BUILDING PERMIT REPORT

DATE: 12-Sept, -97 ADDRESS: 3 ST. John ST.
REASON FOR PERMIT: To install signage
BUILDING OWNER: Sweetser Children's Services
CONTRACTOR: Gracie Graphics
PERMIT APPLICANT: Michael Baker APPROVAL: DENIED
USE GROUP B-R-2 BOCA 1996 CONSTRUCTION TYPE 4/

New Granite Sign Proposal

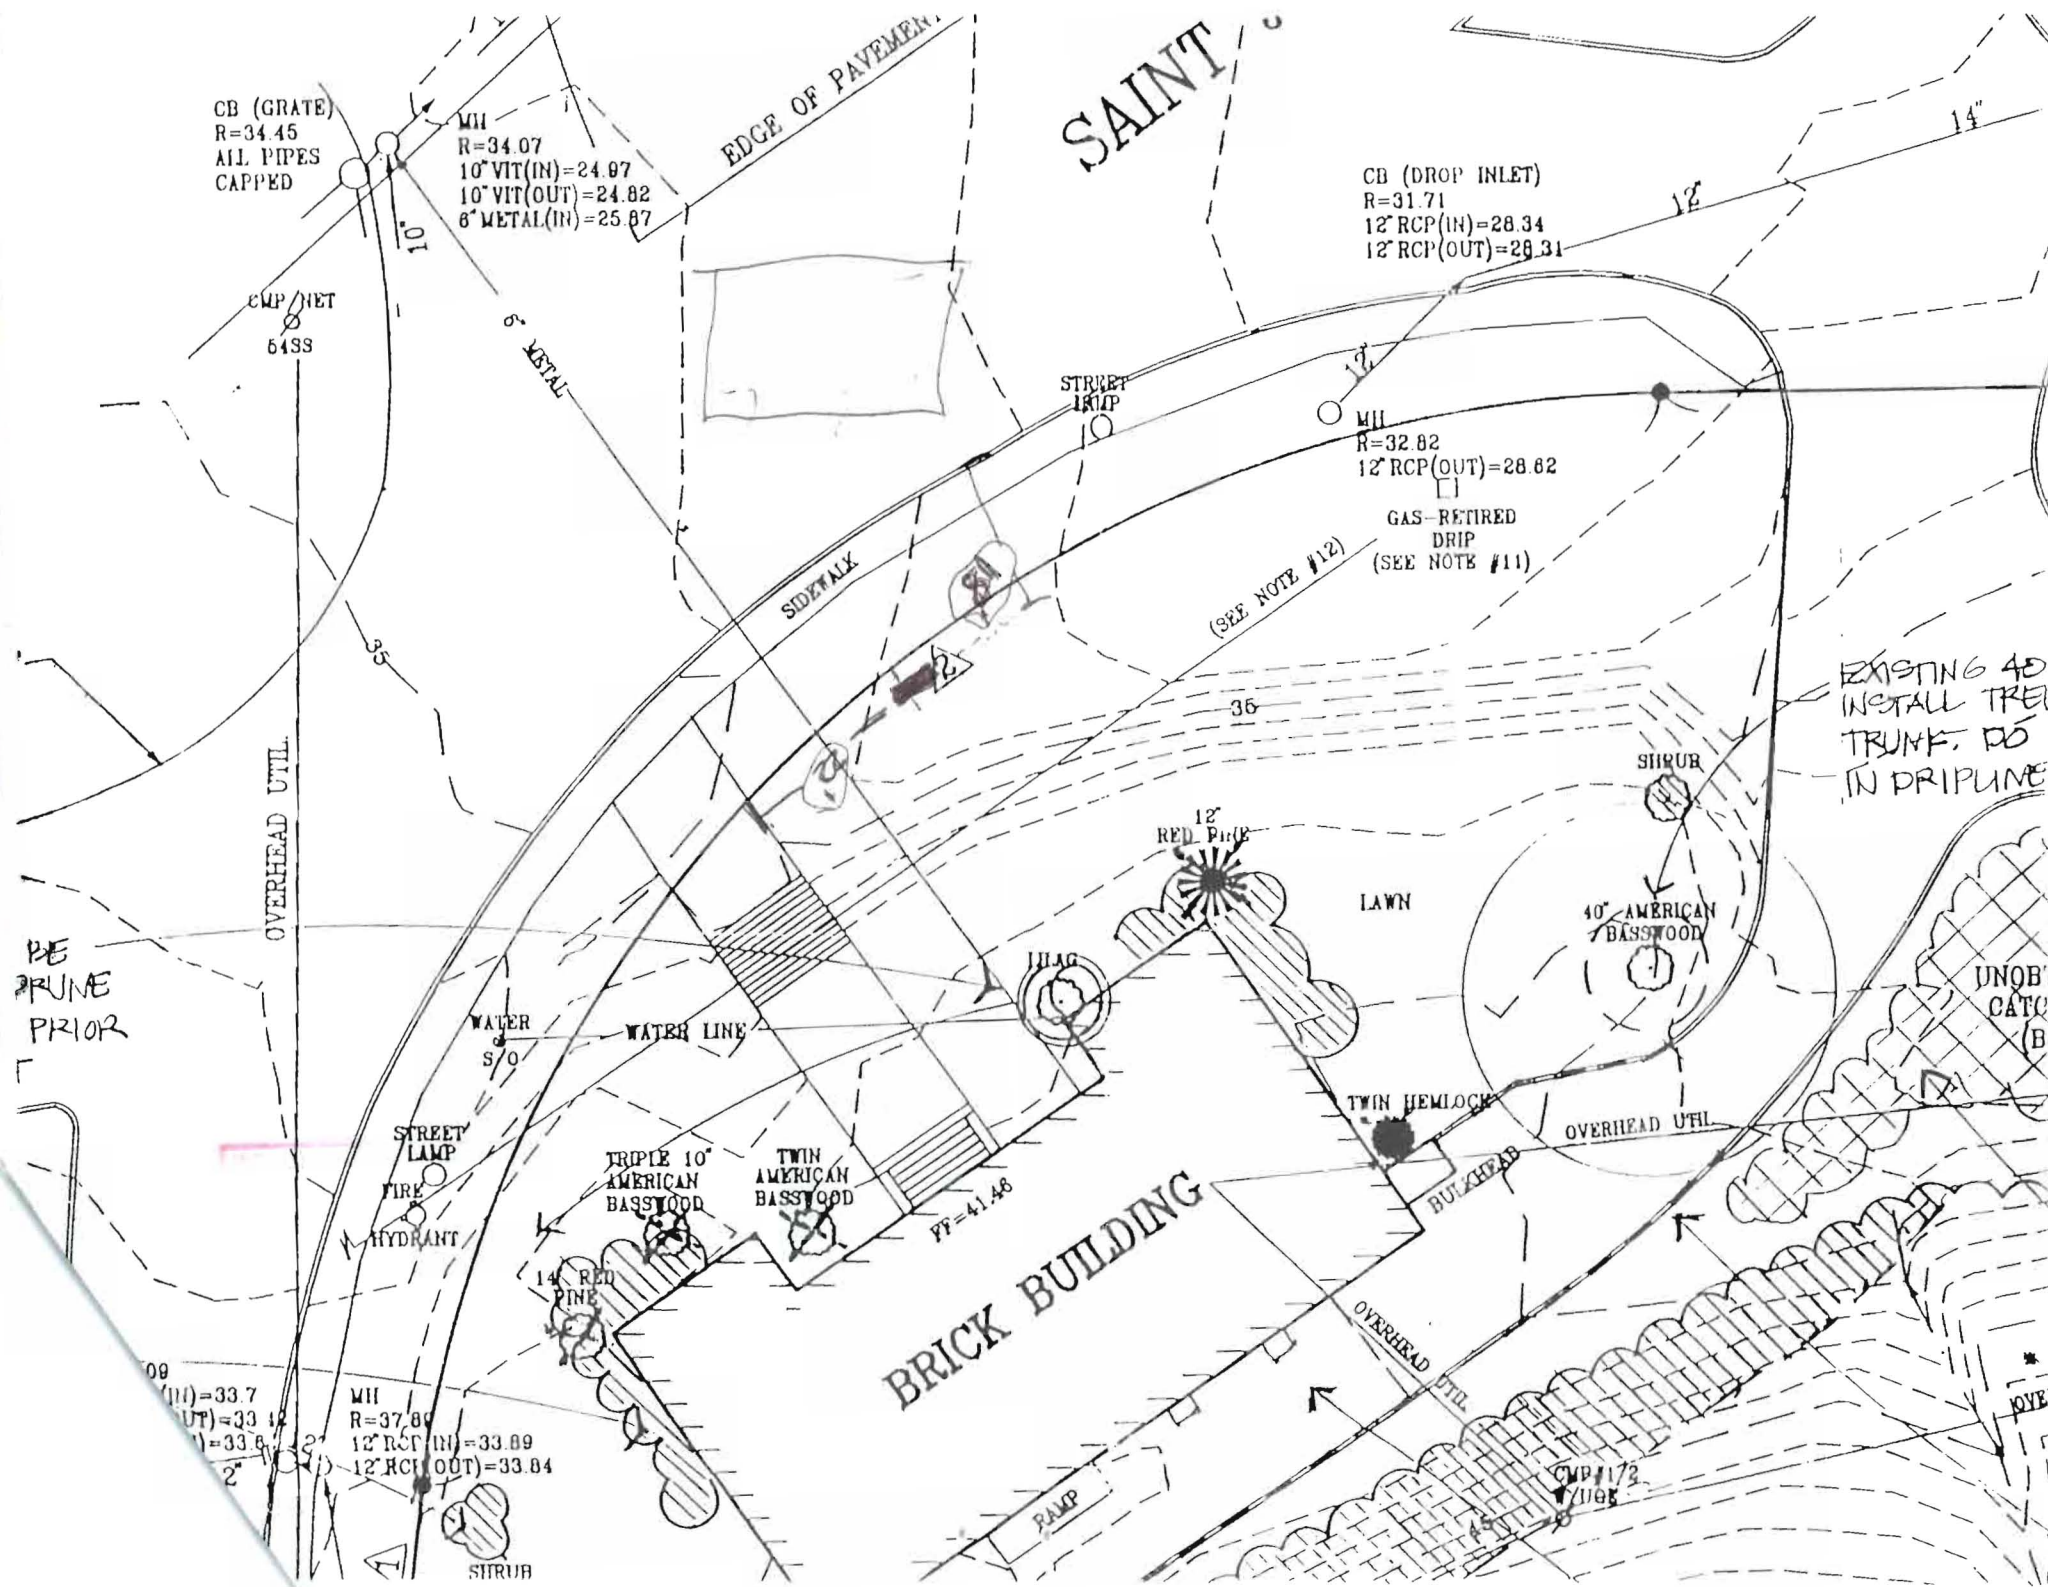
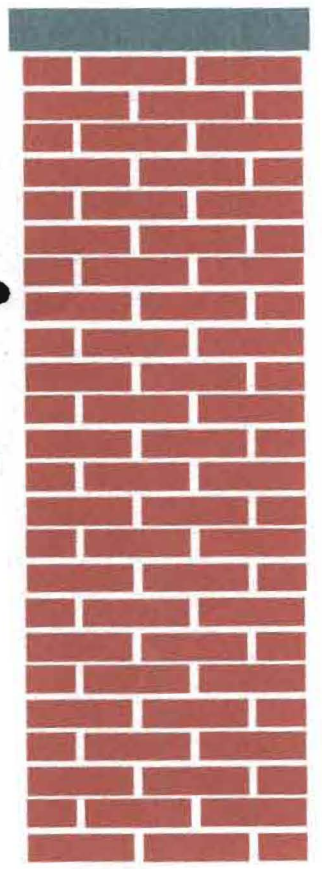
- 30. *Approved with exception of caps on posts, applicant to consult with Historic Preservation (Ms Andrews) for modifications*
- 31. _____
- 32. _____
- 33. _____
